Responses to Agency/ Key Stakeholder Submissions

Appendix B

Table B-1 *Parkes Shire Council*

Figure 1 - Work Area 3 - Mapping Discrepancies

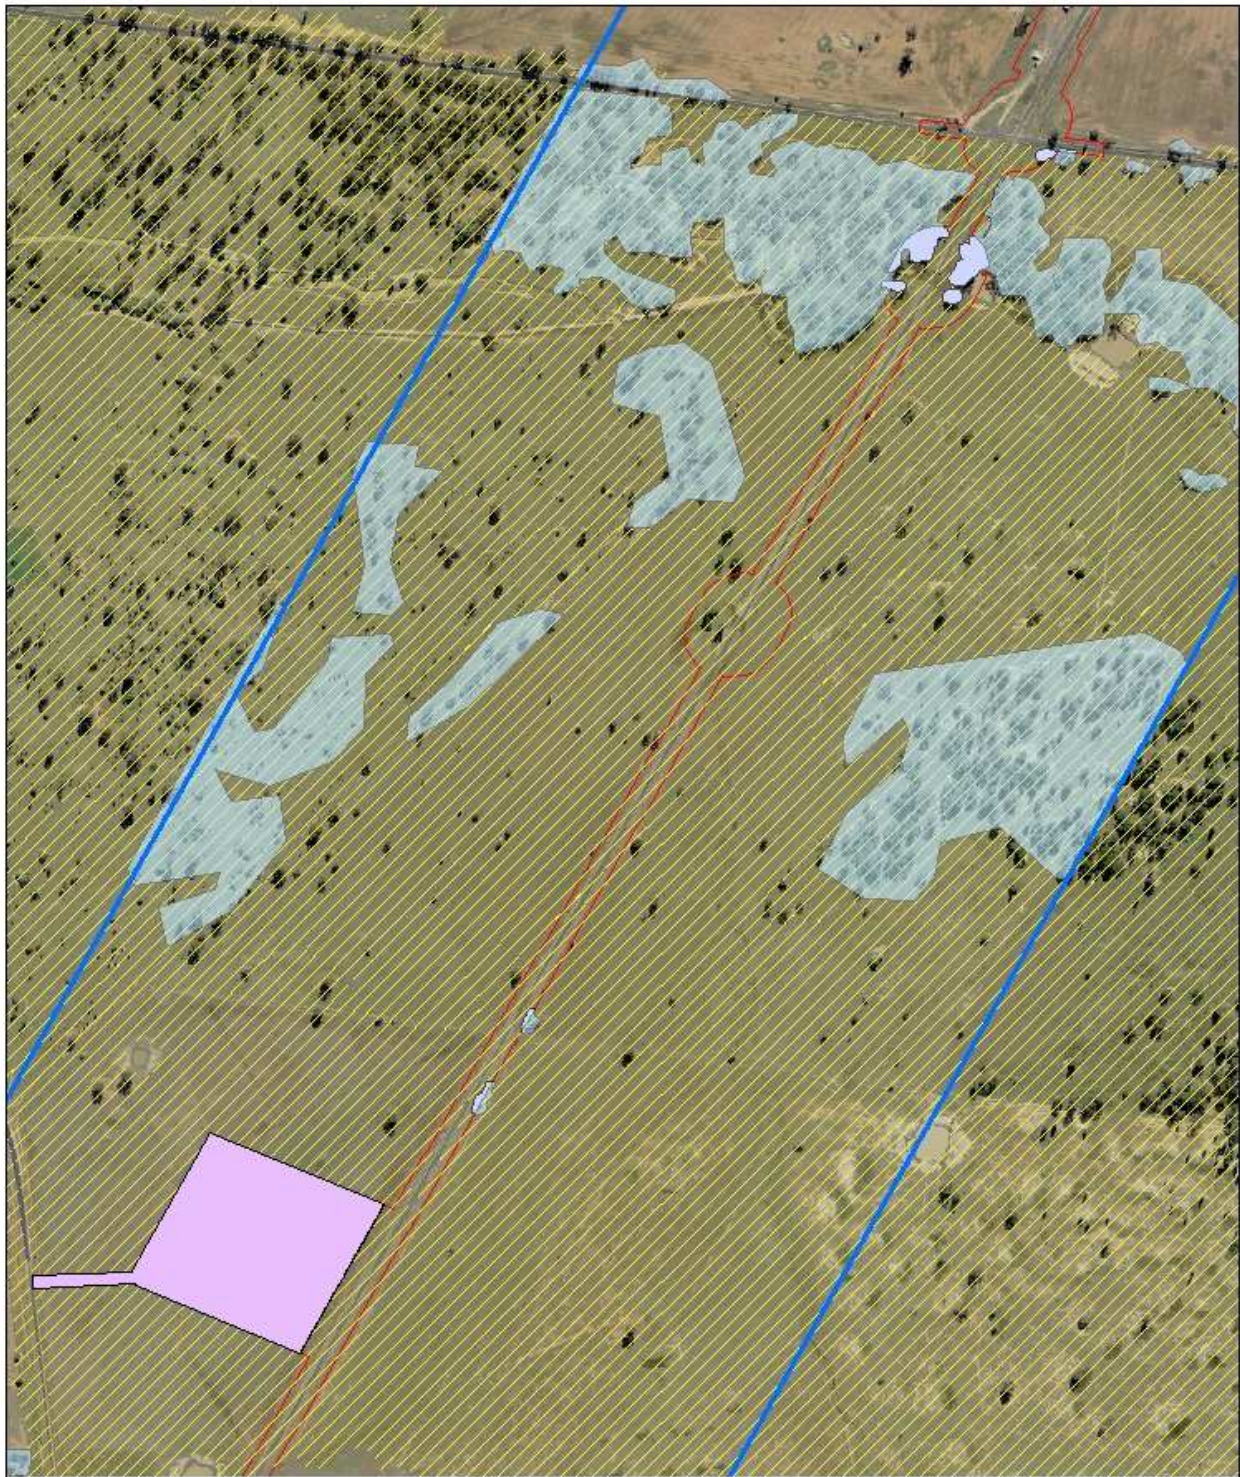
Incorrect identification of full native vegetation extent in the buffer area and development footprint	Biodiversity	The native vegetation mapping should be reviewed and updated to ensure that the identified deficiencies have been addressed. Relevant components of the BAR and BioBanking Credit Calculator must be updated following this review.	<p>A review of the native vegetation mapping results, provided in Technical Report 2 and summarised in chapter 10 of the EIS, was undertaken. Some errors in reporting were noted in the mapped areas provided in technical reports 2 and 4. As a result, the calculations for temporary and permanent impacts to native vegetation, including those that conform to EPBC and/or TSC Act listed communities, are provided in section 5.1.1 of this report. It was confirmed that these errors are only reporting errors/typos, and they do not impact the BioBanking credit calculations provided in Technical Report 2. In any event, once the detailed design has been completed, the design will be reviewed and the <i>Framework for Biodiversity Assessment</i> credit calculations for the proposal will be revised to generate the final ecosystem and species credit requirements. In accordance with mitigation measure D3.2, ARTC commits to minimising the construction footprint and avoiding impacts to native vegetation as far as practicable during detailed design and construction planning.</p> <p>With regards to the mapping method, as described in the EIS (in chapter 10</p>

Submission section/item ref	Key issue	Summary of issue	Response
			<p>and Technical Report 2), potential impacts on native vegetation within the proposal site and a 550 metre buffer area have been assessed according to Appendix 5 in the <i>Framework for Biodiversity Assessment</i> (Assessing landscape value for linear shaped developments or multiple fragmentation impacts). According to Appendix 5, the area of native vegetation cover takes into account the extent and condition of the over-storey cover compared to the benchmark condition. In addition to this, the definition of 'per cent native vegetation cover' in the <i>Framework for Biodiversity Assessment</i> states that:</p> <p><i>'Cover estimates are based on the cover of native woody and non-woody vegetation relative to the approximate benchmarks for the PCT, taking into account vegetation condition and extent. Native over-storey vegetation is used to determine the per cent cover in woody vegetation types, and native ground cover is used to assess cover in non-woody vegetation types.'</i></p> <p>As all PCTs identified within and surrounding the proposal site are presently, or were previously, woody vegetation types in the form of woodlands, only the current woody vegetation forms of these PCTs have been included in the per cent native vegetation cover as per the above definition. Areas of derived native grasslands were not included in the per cent native vegetation cover calculations as they do not contain a native over-storey.</p> <p>It is noted that the Central West/Lachlan State vegetation map (SVM) (OEH, 2016) is an updated regional vegetation mapping product that covers the study area. Prior to the release of the SVM, the latest relevant regional mapping was the <i>Reconstructed and Extant Distribution of Native Vegetation in the Central West and Lachlan Catchment</i> (DEC, 2006b). This mapping was used by the biodiversity assessment to scope and guide the field survey effort. The SVM was not available when the field surveys and vegetation mapping was undertaken. However, as two products were completed at a regional scale, vegetation in the proposal site was ground-truthed to accurately map the vegetation zones (combination of PCTs and broad condition states) in the proposal site. This involved meandering transect surveys, 48 systematic</p>

Submission section/item ref	Key issue	Summary of issue	Response
			<p>plots/transects, and 214 rapid vegetation assessments.</p> <p>Digital aerial photography interpretation of high resolution aerial photographs was also undertaken to map vegetation zones with the proposal site and native vegetation within the surrounding 550 metre buffer area. The regional vegetation mapping was only used to inform the field survey component of the assessment prior to the completion of surveys, and to determine the extent and likely composition of PCTs likely to be encountered during field surveys.</p> <p>Following the completion of field surveys, the PCTs encountered were mapped in GIS using high resolution aerial photographs. The regional vegetation mapping was not used to map any of the proposal site and was not used in any way that contributed to the allocation of ecosystem credits for these PCTs.</p> <p>This level of survey effort allowed detailed vegetation mapping to be completed, which included defining vegetation zones and threatened ecological communities, and establishing the boundary between derived native grassland and exotic grassland.</p> <p>As described in the EIS, six plots/transects were completed in exotic grassland areas within the proposal site. The site value achieved was 8.85, which is below the site value score of 17 required for offsets to be calculated in accordance with the <i>Framework for Biodiversity Assessment</i>.</p> <p>ARTC notes OEH’s request to review the mapping extent of TECs against the NSW Scientific Committee listing advice to ensure the full extent has been captured. In this regard, a thorough review of threatened ecological communities under both the TSC Act and the EPBC Act was undertaken as part of the biodiversity assessment. Appendix D (Threatened ecological community analysis) of Technical Report 2 includes a thorough assessment of each of the relevant vegetation zones within the proposal site against NSW Scientific Committee and/or the Commonwealth <i>Threatened Species Scientific Committee Guidelines</i> (Threatened Species Scientific Committee), and listings under the TSC Act and EPBC Act., ARTC will provide the required information to OEH in accordance with their request (including the rapid vegetation</p>
